**Atchison Street
St Leonards, NSW**

Department Letter Response

Our ref: Shop Top Housing – 20-22 Atchison Street (SSD-87486461)

Subject: Department's Key Issues

- 1400mm Glass Balustrade with Fixed Louvres Above

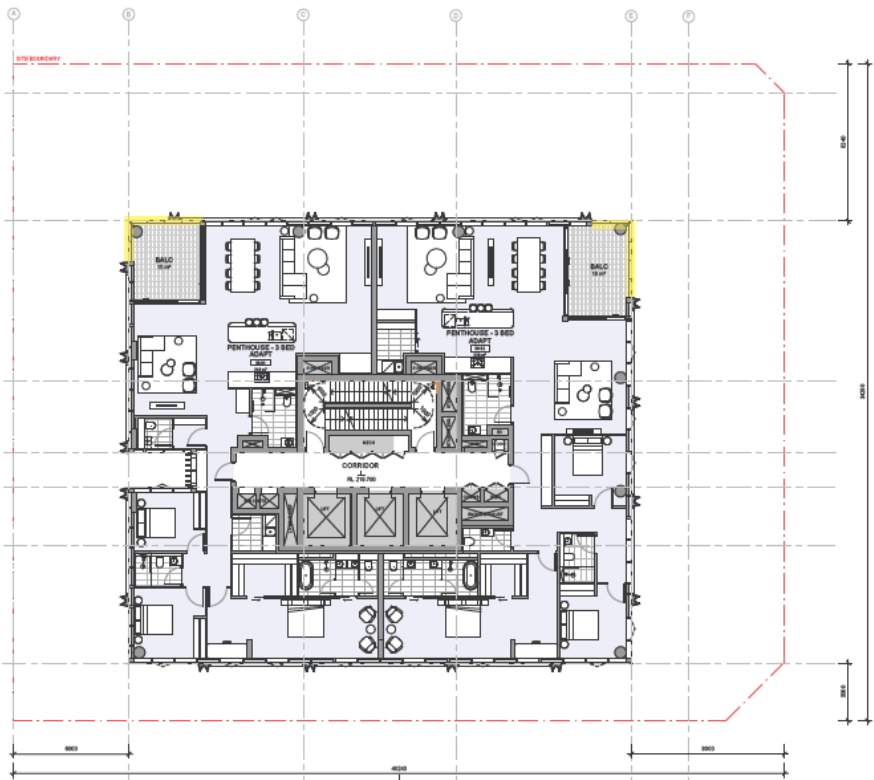
The fixed glass louvres included throughout the residential levels of the building allow for fully enclosed balconies and are therefore considered residential gross floor area (GFA) in accordance with the North Sydney Local Environmental Plan 2013. The balcony balustrades on Levels 2 and 3 also exceed 1.4 metres in height, potentially contributing to additional GFA.

10.5m WASTE TRUCK SWEPT PATH (TYP.)
(0.6m CLEARANCE SHOWN)

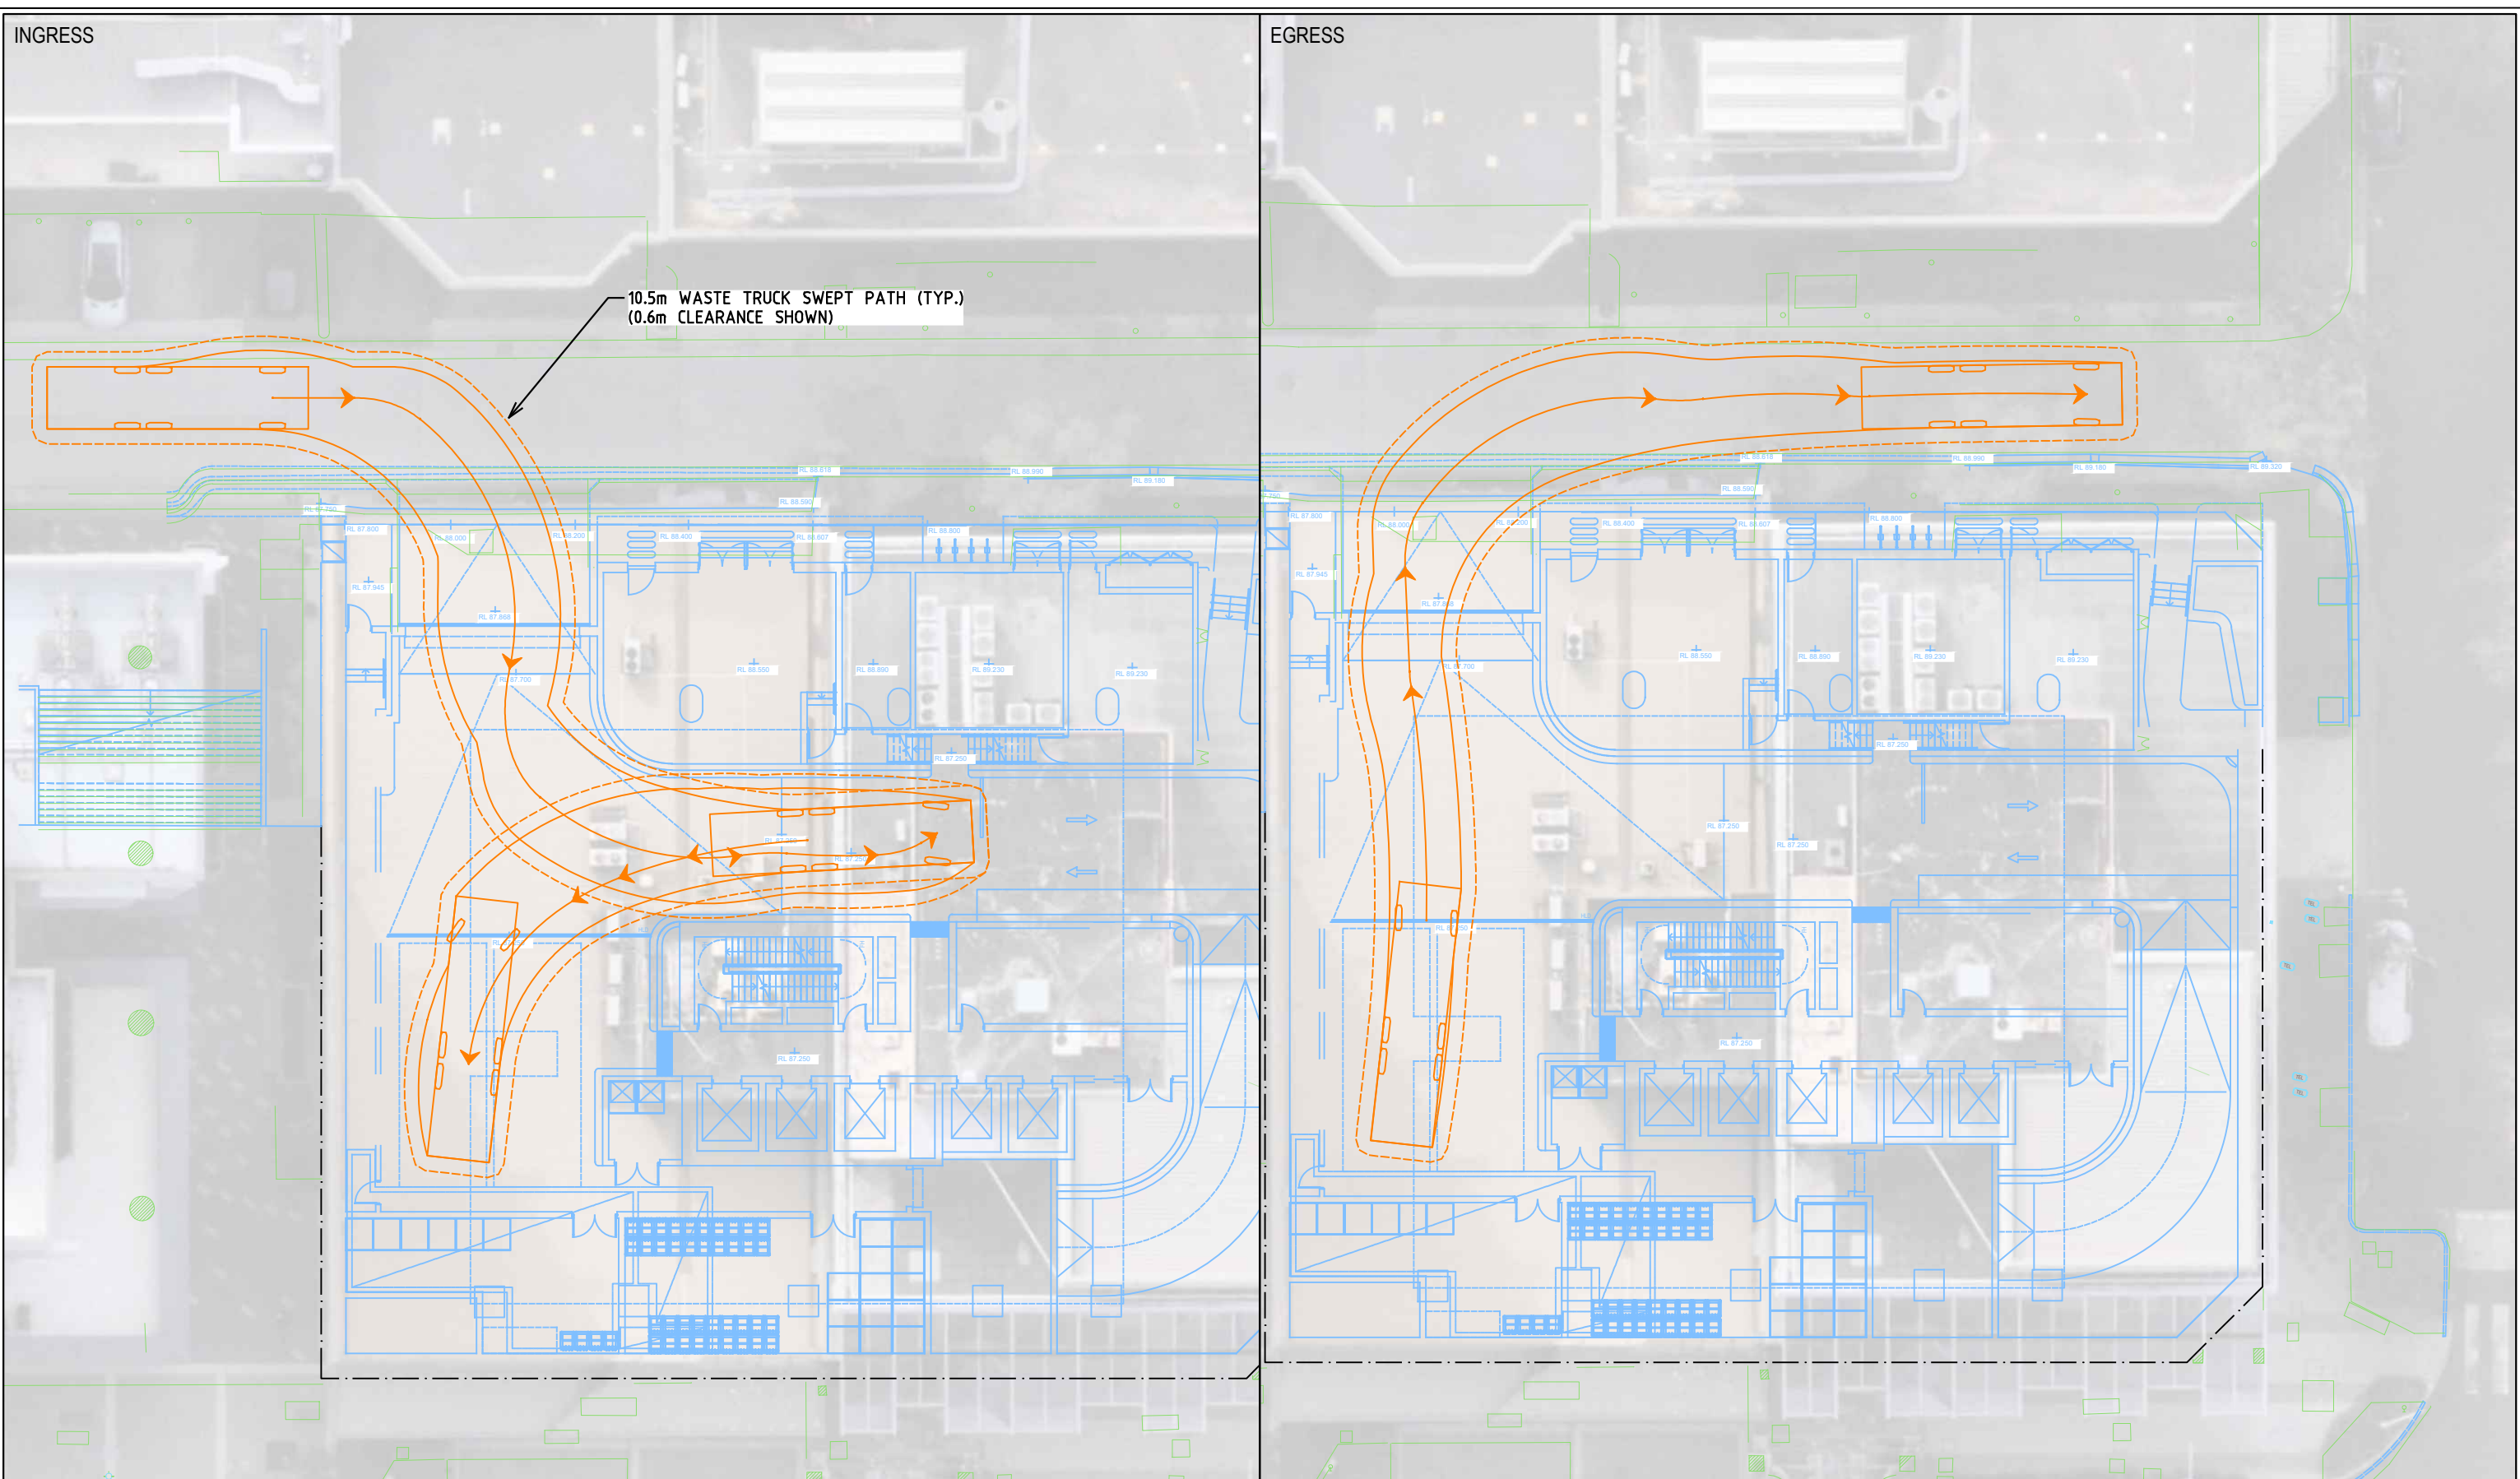
- d) Confirm that the development has been designed to enable on-site waste collection by Council's waste collection fleet, including adequate access and manoeuvring space.

Figure 4 Ground Floor Café Activation Plan

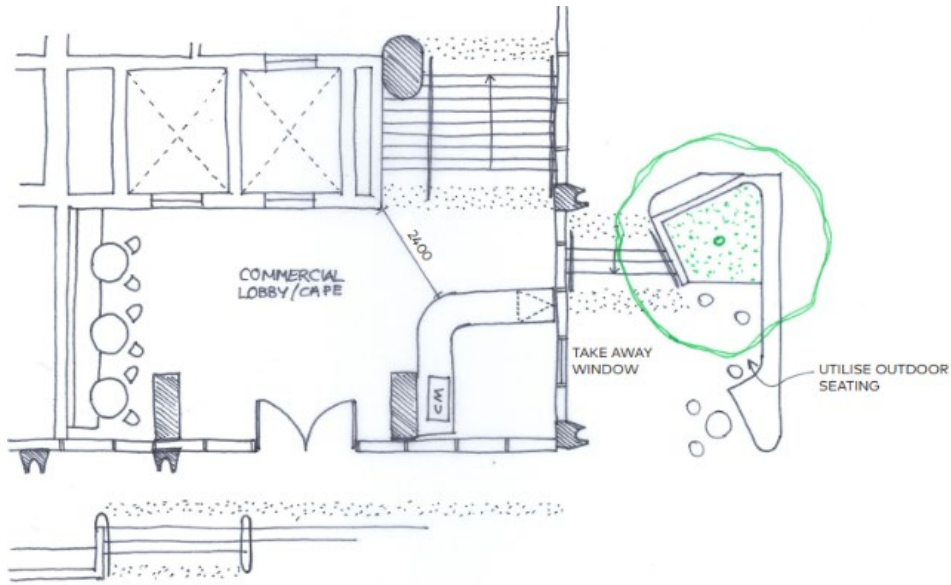
- a) Consider alternative design options or removal of the fixed glass louvres to reduce the bulk and scale of the development and ensure compliance with the FSR control.
- b) Street activation along the Atchison Street and Mitchell Street frontages should be further explored to accord with the Crows Nest TOD Precinct Design Guide.
- c) Consider improved street activation and/or landscaping of the through-site link along the western boundary of the site to screen the inactive facade.

- Cafe can operate within the Commercial Lobby, servicing staff internally, and the public through a take away window opening onto the Mitchell Street green link.
- Cafe customers can utilise and activate the landscaped seating of the Mitchell Street green link.
